DECISION DELEGATED TO HEAD OF PLANNING

Application No: H16-0627-26 **Applicant:** CJNI Spalding Ltd

Proposal: Replacement of existing defective timber-framed single glazed windows to the front and rear elevations of building, with new like-for-like uPVC double-glazed window units

Location: Beechfield House 19b High Street Spalding

Drawing Title	
Existing Elevations	
Location	
Beechfield House, Spalding, PE11 1UD	
Drawing No.	Date
BHEX002	10 June 2026
Scale	Rev
As Seen @ A3	001

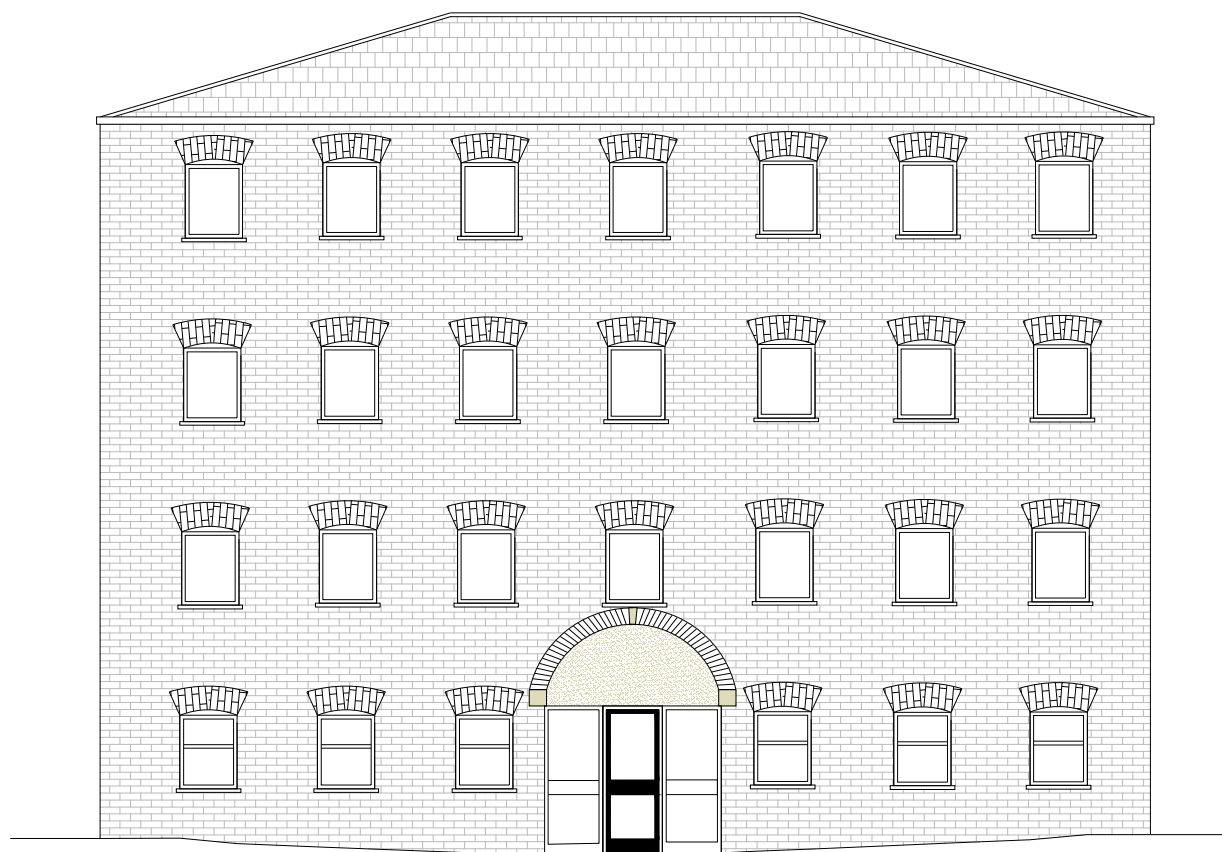
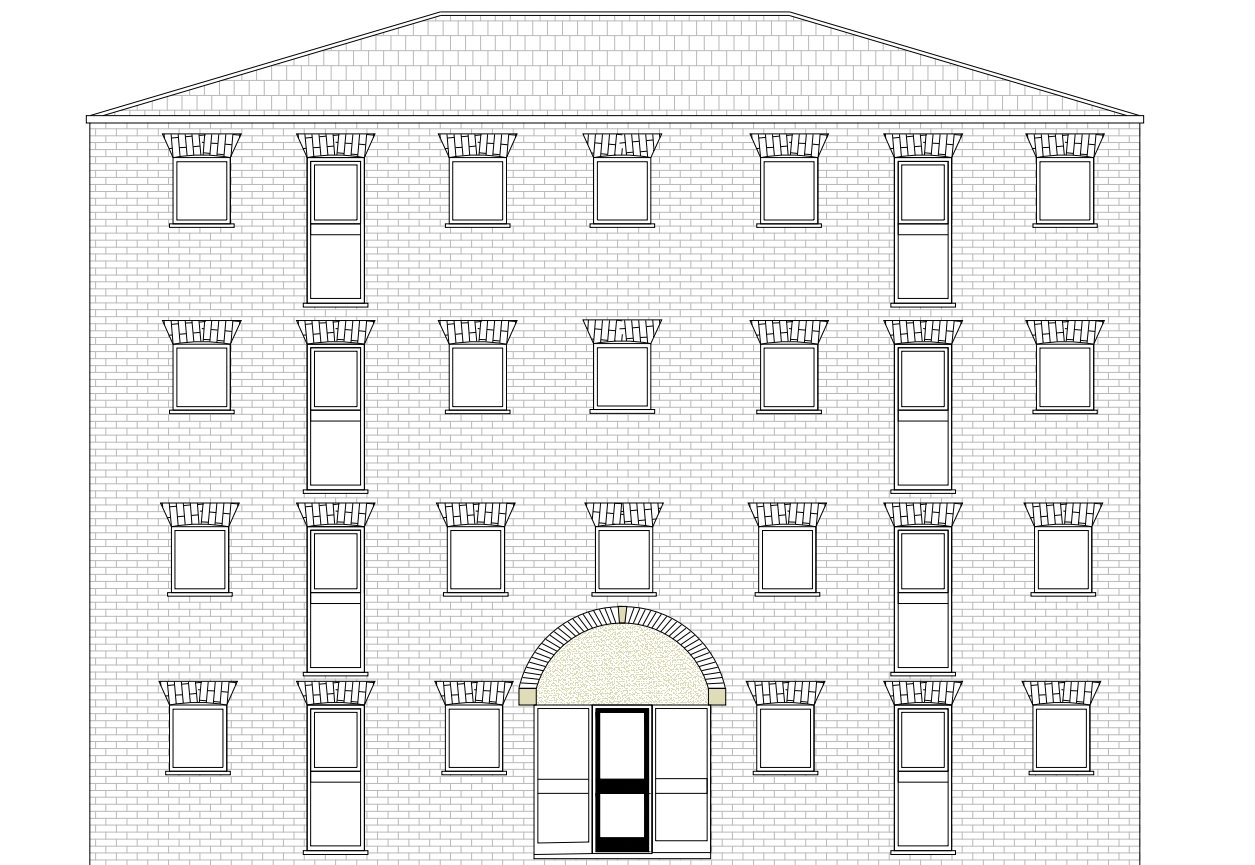
Moreover, whilst the applicant suggests the proposed windows are 'like for like', this is incorrect as they do not replicate the timber materials and the glazing pattern of several windows is subtly different. Moreover, the applicant has not provided exhaustive sectional drawings of the proposed new windows with full measurements included and so with the detail included on the simple plans provided thus far, it is not possible to accurately compare measurements with regard to frame thickness, format etc.

Statement 5 included within Section 6.1 of the included HIA, demonstrates a concerning lack of consideration and knowledge of the requirements for conserving a listed asset by asserting that simply because the rear elevation is less prominent, that the impact of harmful works is lesser.

This is a listed building, the entirety of the building is listed, and so harm is equally unacceptable in all positions - albeit the impact to the conservation area is lesser.

Whilst views of the rear would be less prominent, views from the public realm would still be available from Beechfield Gardens and Holland Road. The Beechfield Medical Centre and carpark to the rear of the application site would result in a greater level of footfall, thereby increasing the impacts of development. In any event, this element would still affect the asset as a whole, as per the Conservation Officer's comments; and therefore, whilst the effect of changes upon the setting of the building would be less, the effect upon the asset itself would be the same regardless of positioning. As such, the rear elements would also fail to preserve or enhance the listed building.

The applicant would be far better served by proposing to install genuine timber, period appropriate flush fitting timber, side opening casement windows with a central meeting point or flush fitting

timber sliding sash windows, neither with any cill. These sorts of windows were those most commonly used in period warehouses.

<u>Drawing Title</u> Existing Window Elevations	
<u>Location</u> Beechfield House, Spalding, PE11 1UD	
<u>Drawing No.</u> BHEX007	<u>Date</u> 10 June 2026
<u>Scale</u> As Seen @ A3	<u>Rev</u> 001

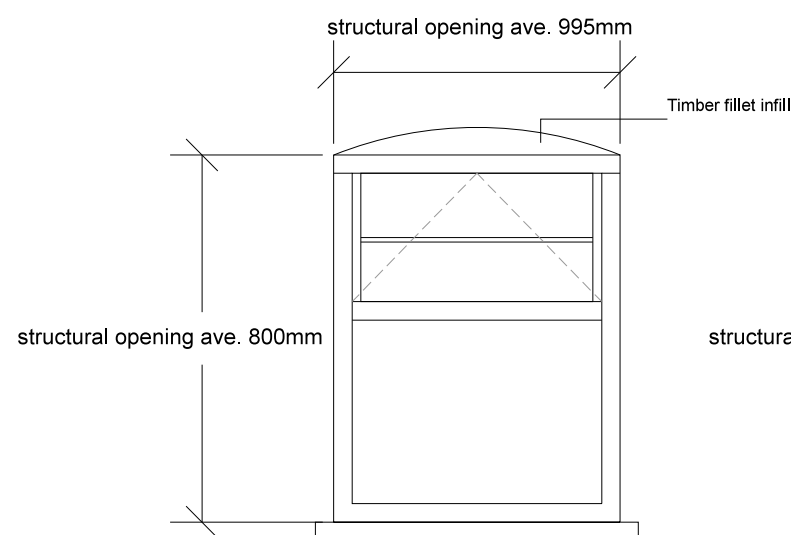
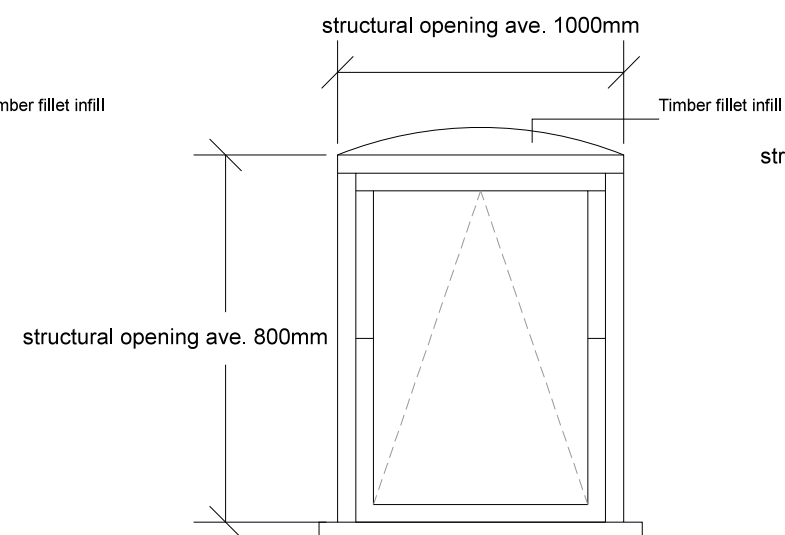
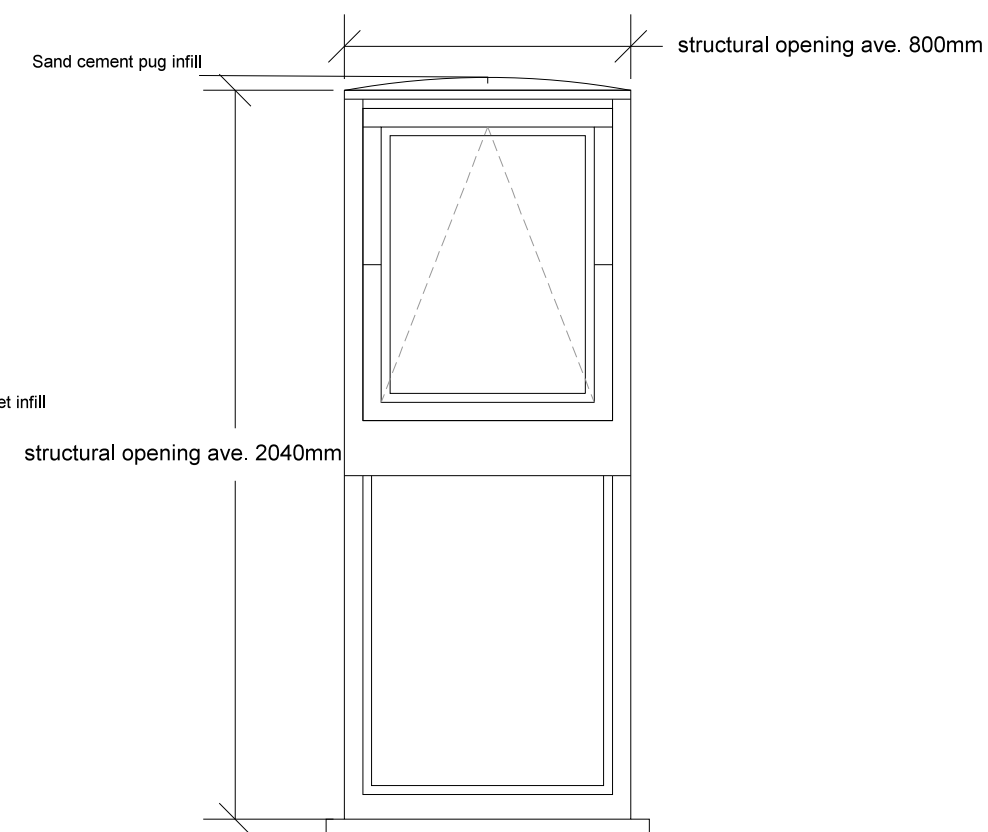
Regardless, the windows currently on the property are of a non-original style that are themselves considered unsightly and not at all period appropriate. As such, I am not satisfied that there even is any value in the existing windows being replicated in style. To agree to a replication of the existing windows would be for the Local Planning Authority to perpetuate a harmful effect upon the listed building.

Detailed drawings to demonstrate the "like for like" quality described by the Applicant have not been provided, therefore it cannot be said with any certainty that the proposal would replicate the existing features to any significant degree.

Moreover, the existing windows which the proposal seeks to replicate are of themselves anachronistic. A lower quality replication of a feature which is already detrimental to the appreciation of the building would simply further degrade the asset.
